Re: MMC Congress Building | 22 Bramhall St | Level III Site Plan
Response to City Reviewer Comments re: Signage

Comments from City of Portland Senior Planner – Nell Donaldson Dated September 4, 2019

Existing Signage Location Plan

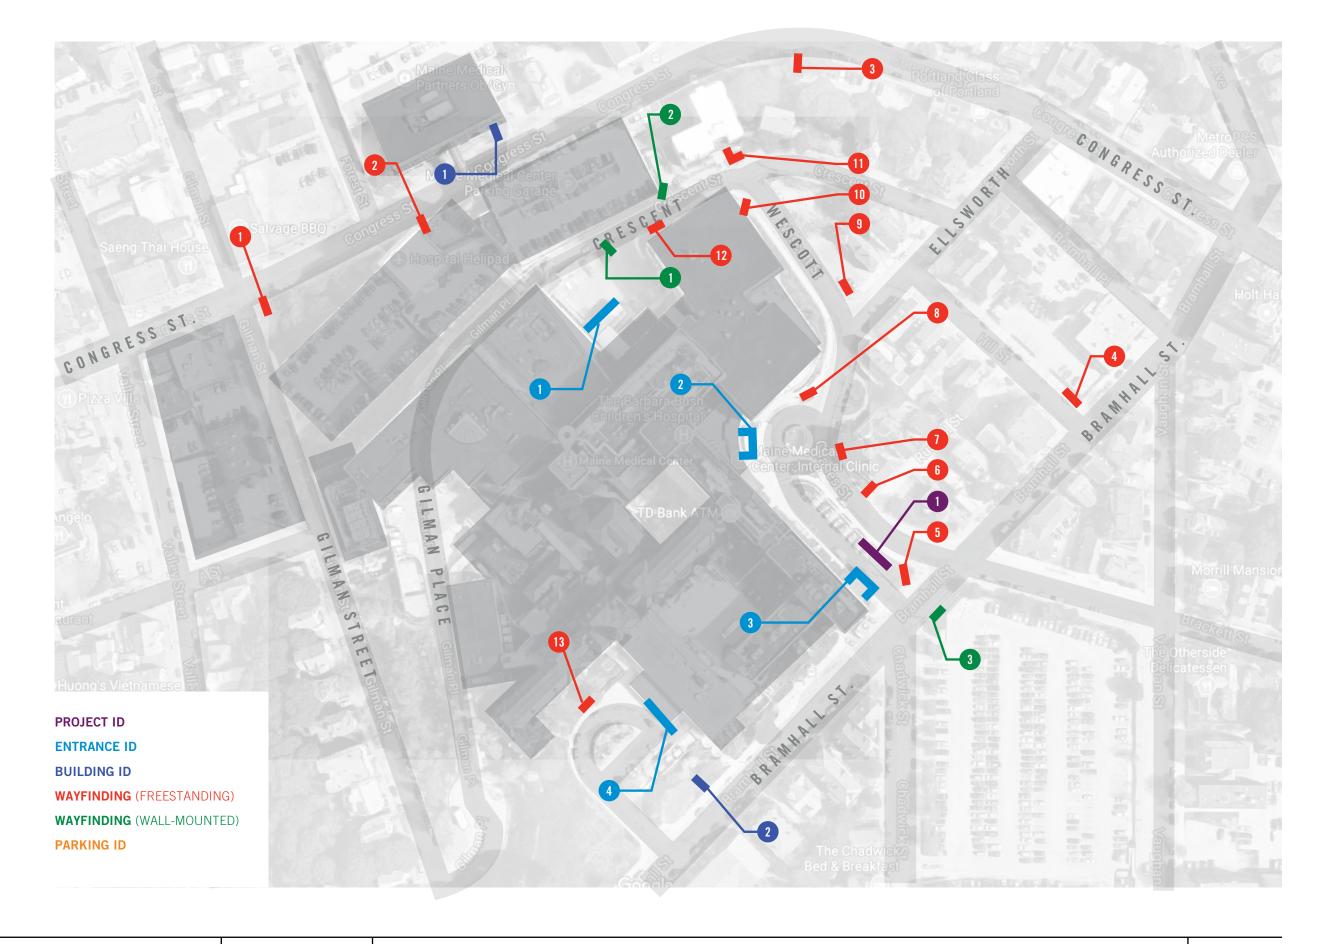
1. *The response from DPW is that supplemental signs in Bramhall Square will not be permitted. The existing signs are designed to comply with MUTCD standards and therefore provide legibility to a wide audience. Kevin Thomas did mention that the design of the existing signs could be discussed, but there is a strong preference for uniformity among these types of signs in the ROW.*

Response: The revised plan does not propose any changes to existing signage on Bramhall Square. MMC requests a meeting with members of the City’s Planning Department and Department of Public Works to discuss alternatives to improve wayfinding at the intersection of Congress Street, Bramhall Street, and Deering Avenue.

Preliminary Sign Location Plan

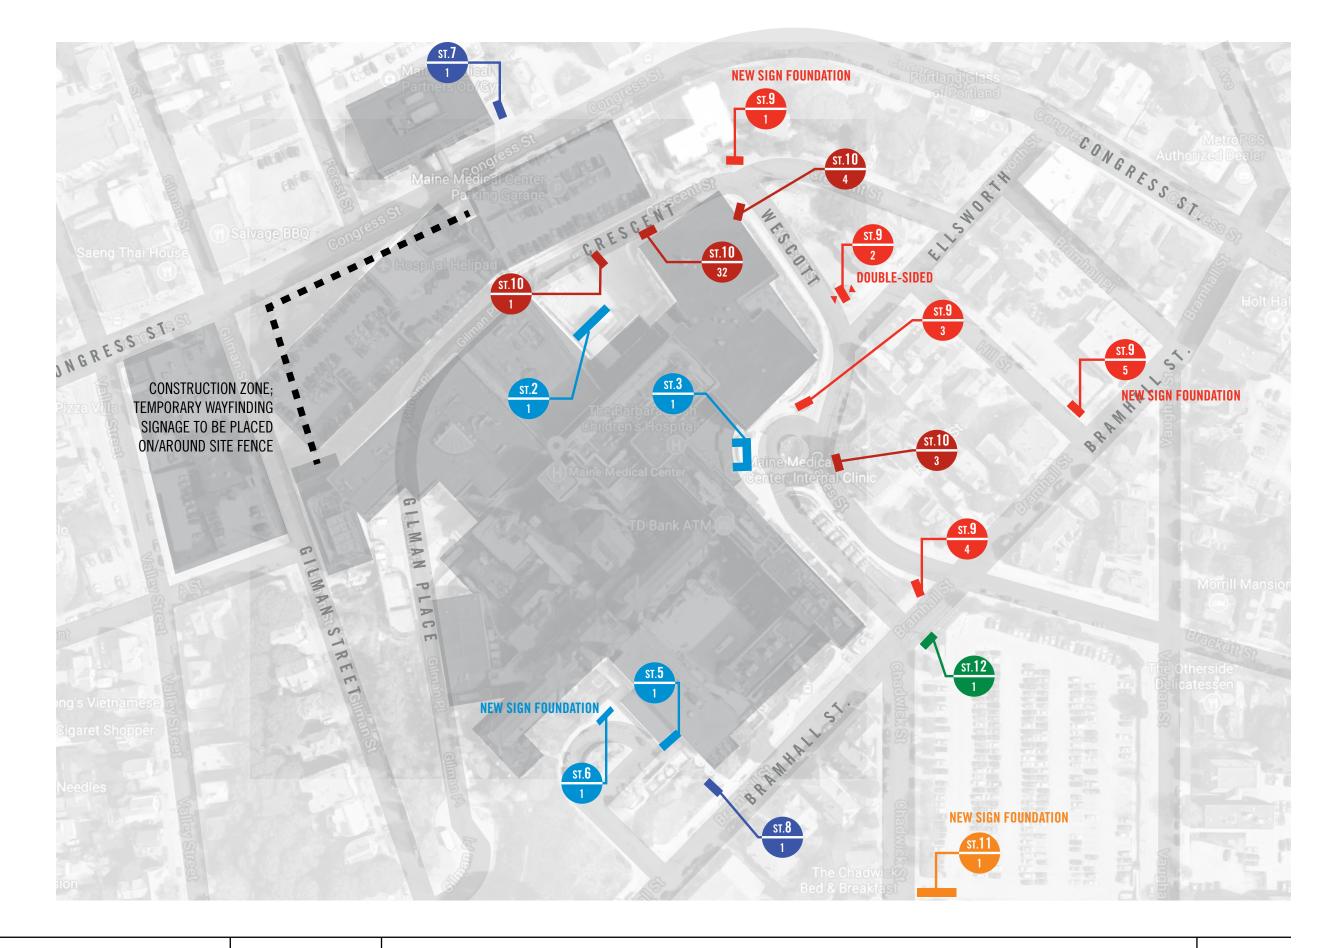
2. *We will need evidence of rights to install MMC signage on private/public property. It is difficult to tell from the graphic in the sign master plan, but I believe that at least 9 and 11 are both proposed for private property. Please confirm. If so, please provide some narrative in the plan that notes this and clearly states that an easement or license will be required prior to the installation of any new signage in these (and any other) locations not owned by MMC.*

Response: MMC will provide a license prior to installation of any new signage or replacement of existing signage at 15 Crescent Street and 25 Ellsworth Street.
